Your Ref: OWPC20805
Our Ref: EP/160/18/PL 02-11-2018
Please ask for:
Mr J Baeza

Variation of condition No.3 imposed under planning reference no: EP/45/17/HH relating to the proposed materials

11 Beechlands Close East Preston

Roof Plan (1:100)

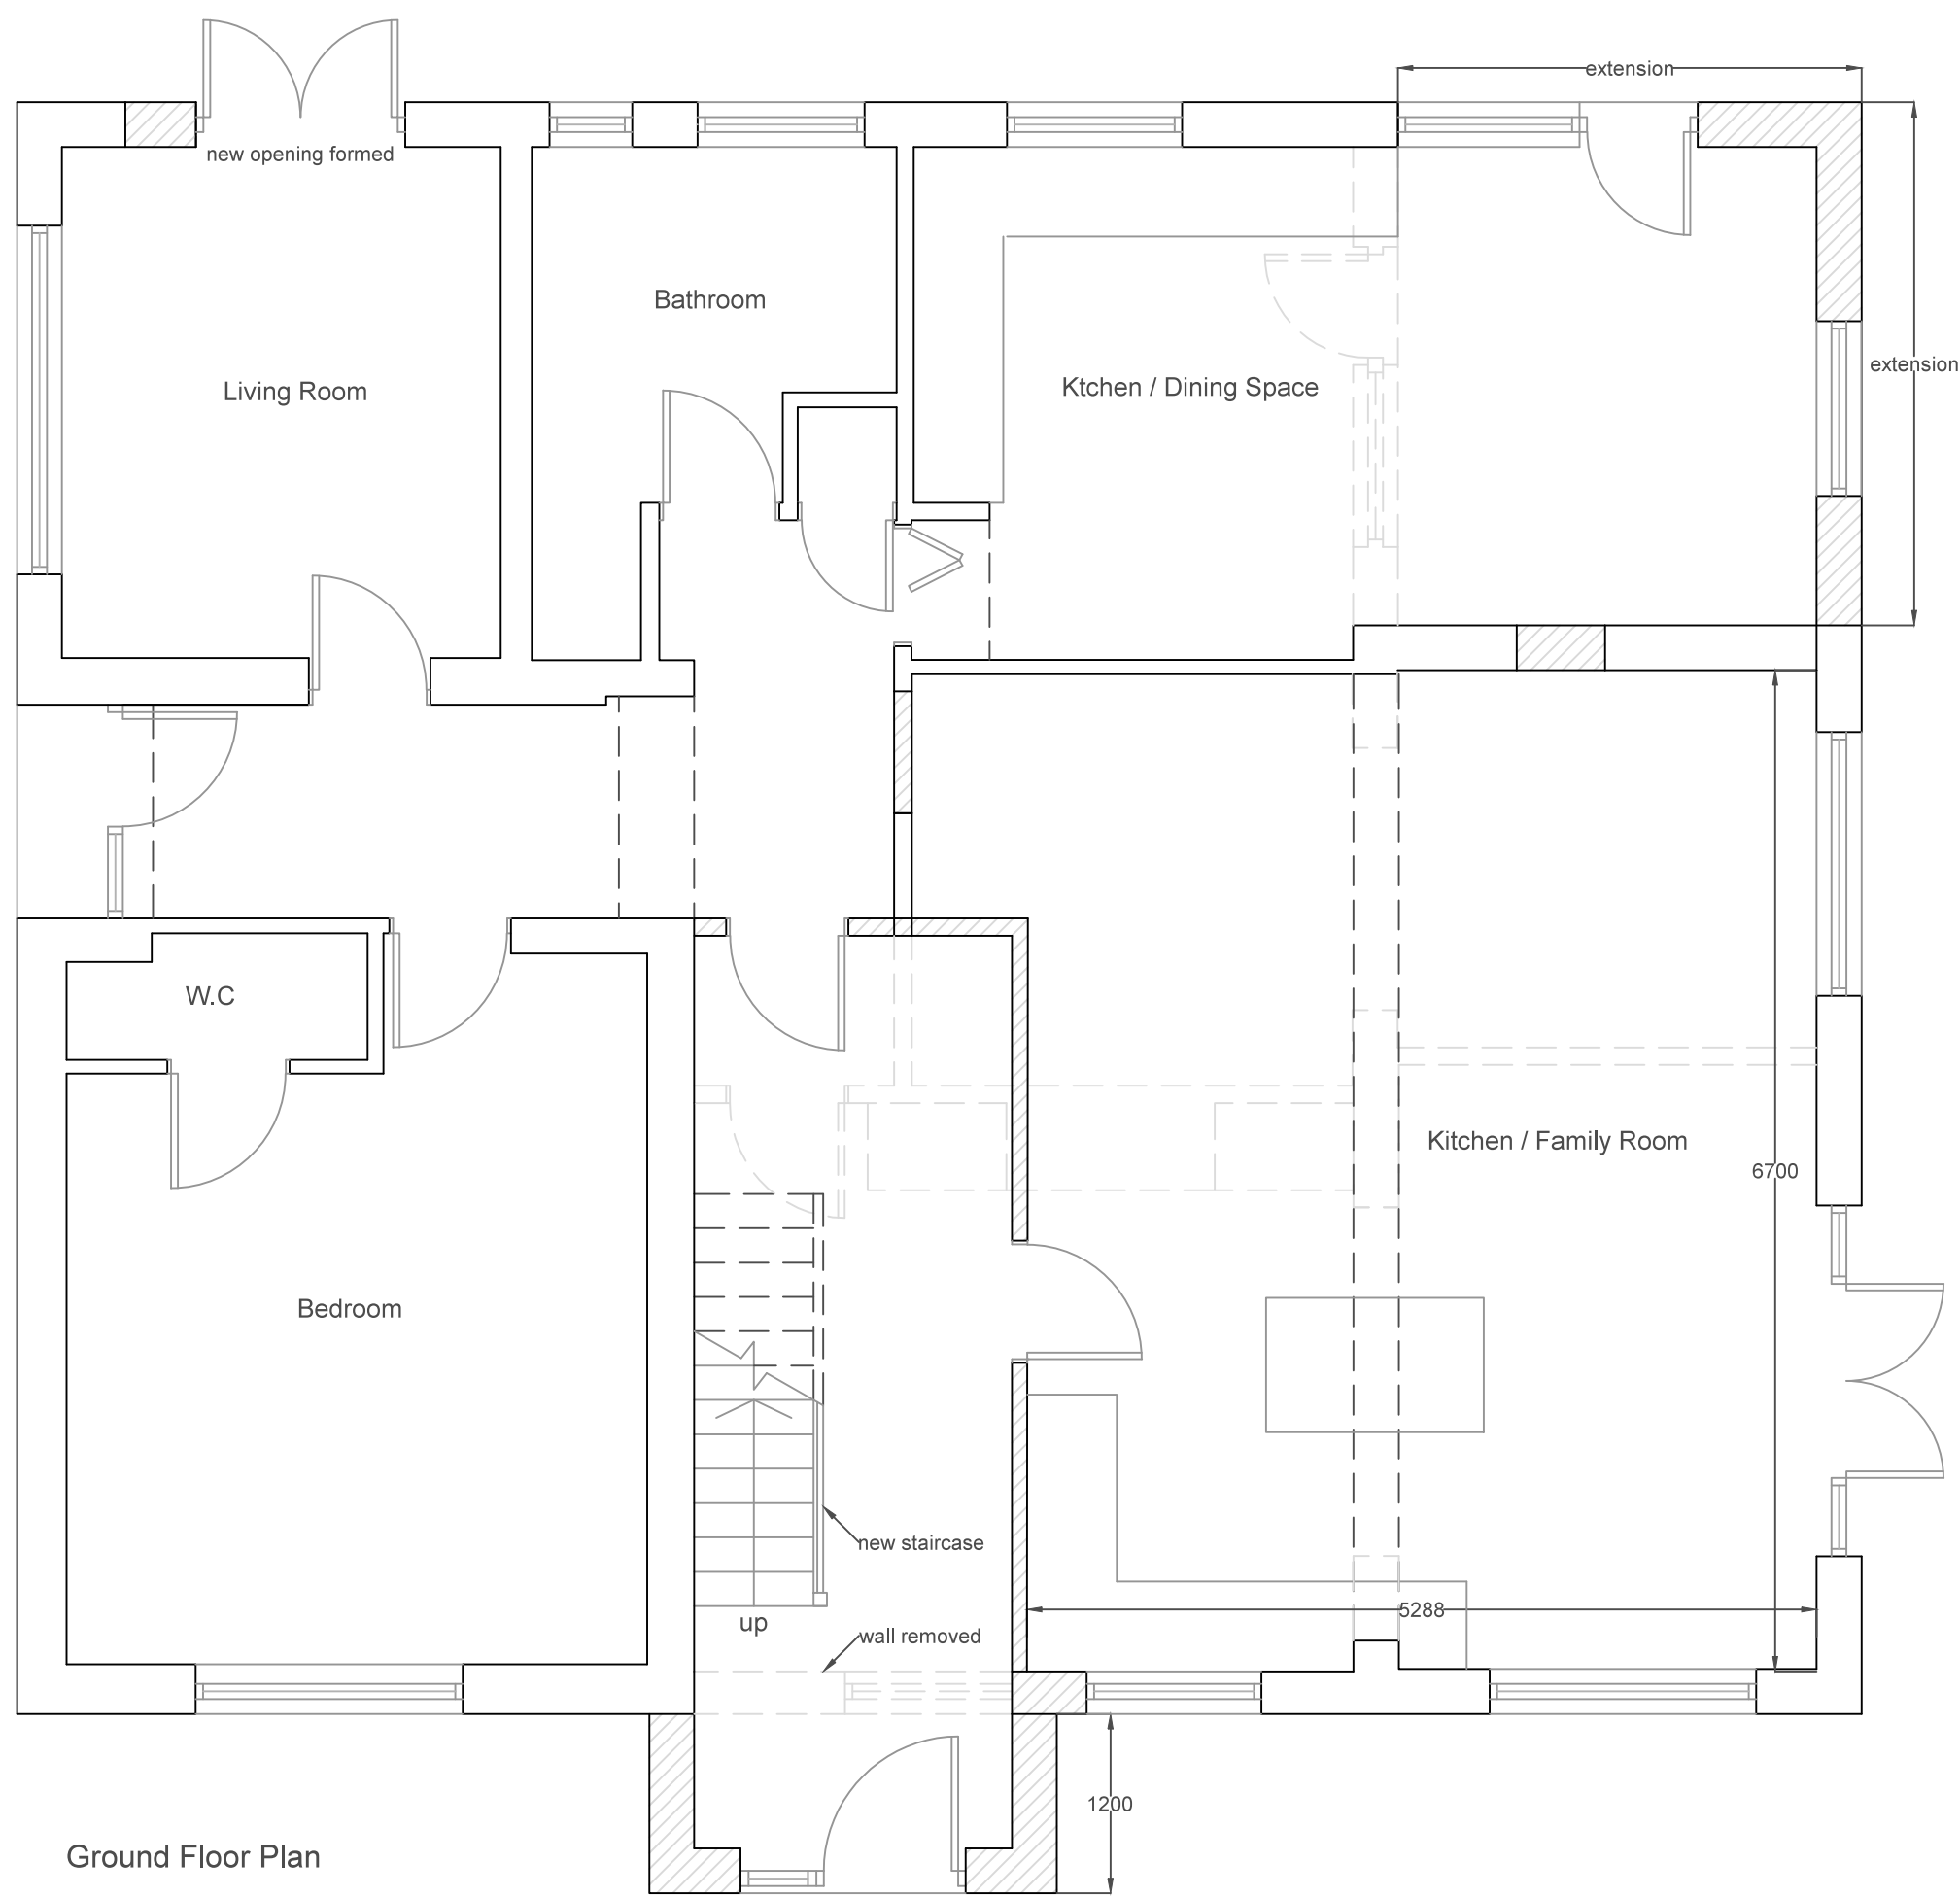
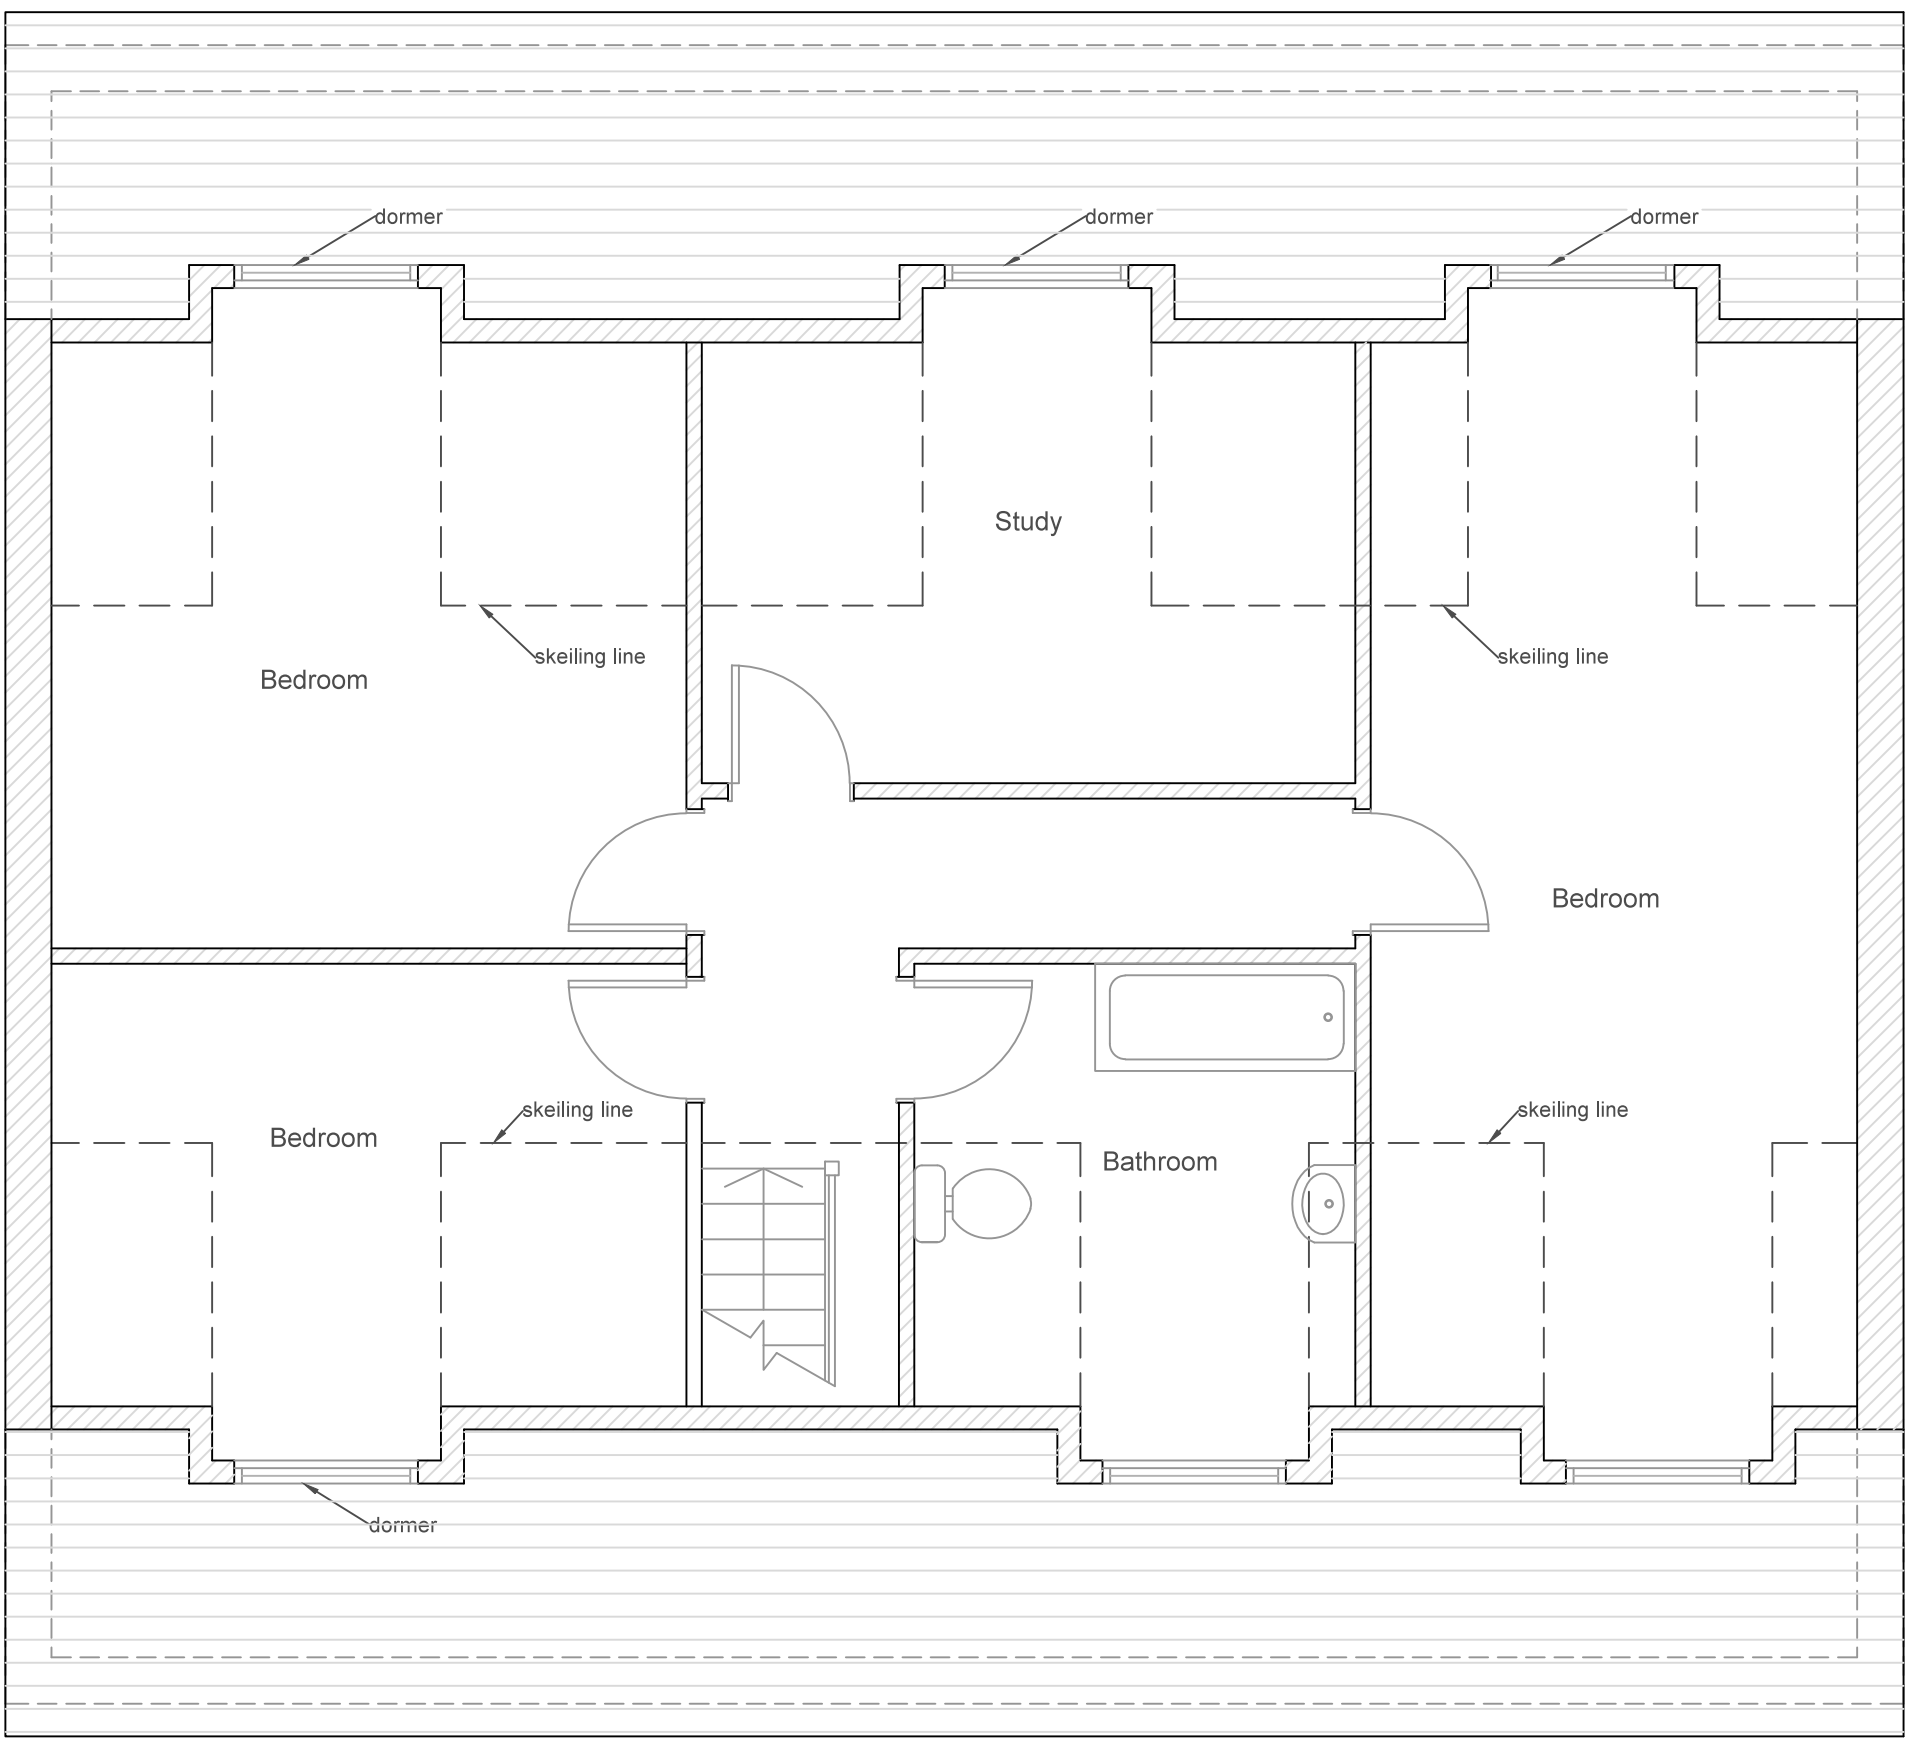
The original planning consent stated that the roofing material on this new house should be the same as the roofing materials removed from the original bungalow and consistent with those on surrounding properties.

The tiles in place now are dark grey and not in accordance with the planning consent.

These grey slate tiles are totally out of keeping with the surrounding properties and nothing like the red terracotta tiles on the original roof .

Proposed Roof Tile – Marley Modern Tile, colour smooth grey.

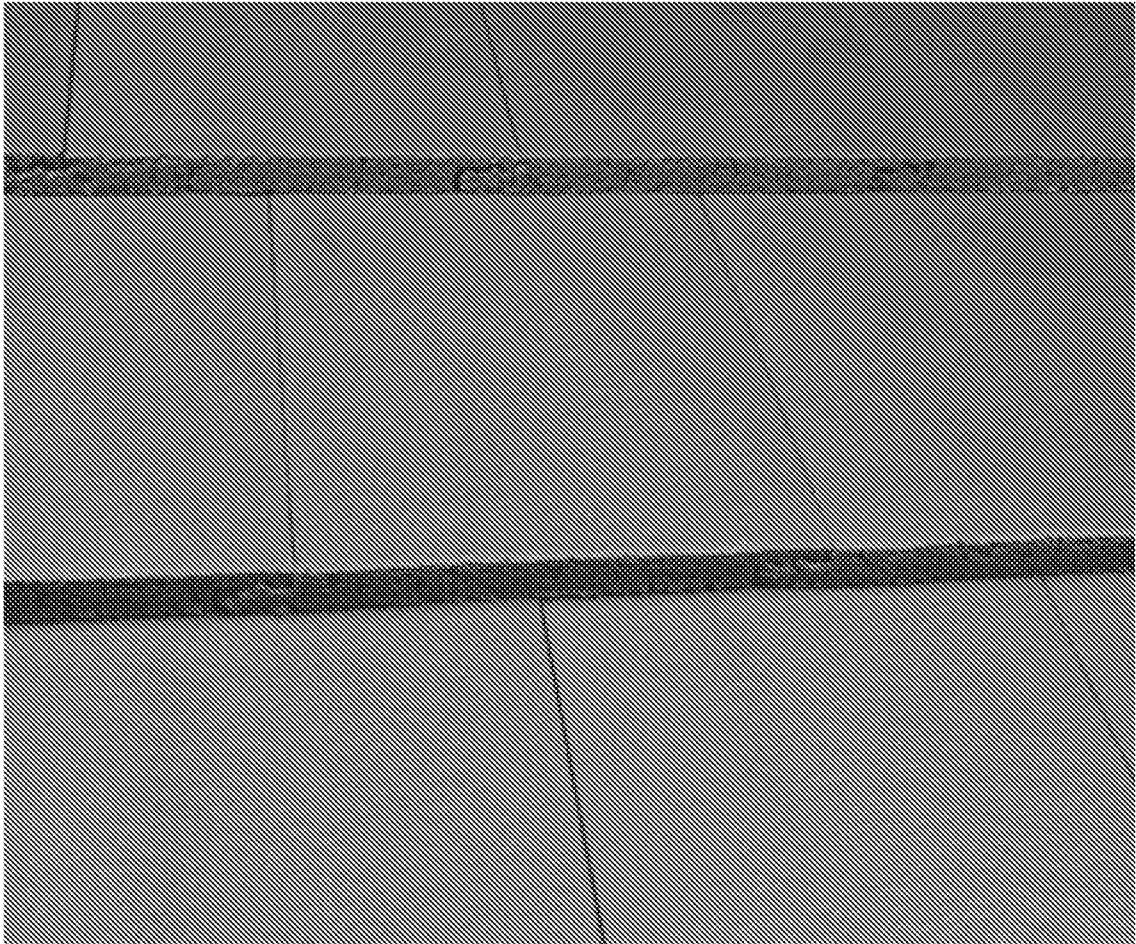
The grey tiles are, as I have said, not as written in the planning consent given, are totally out of keeping with the red tiled roofs of surrounding properties, and make the large building even more of a blight on the surroundings.
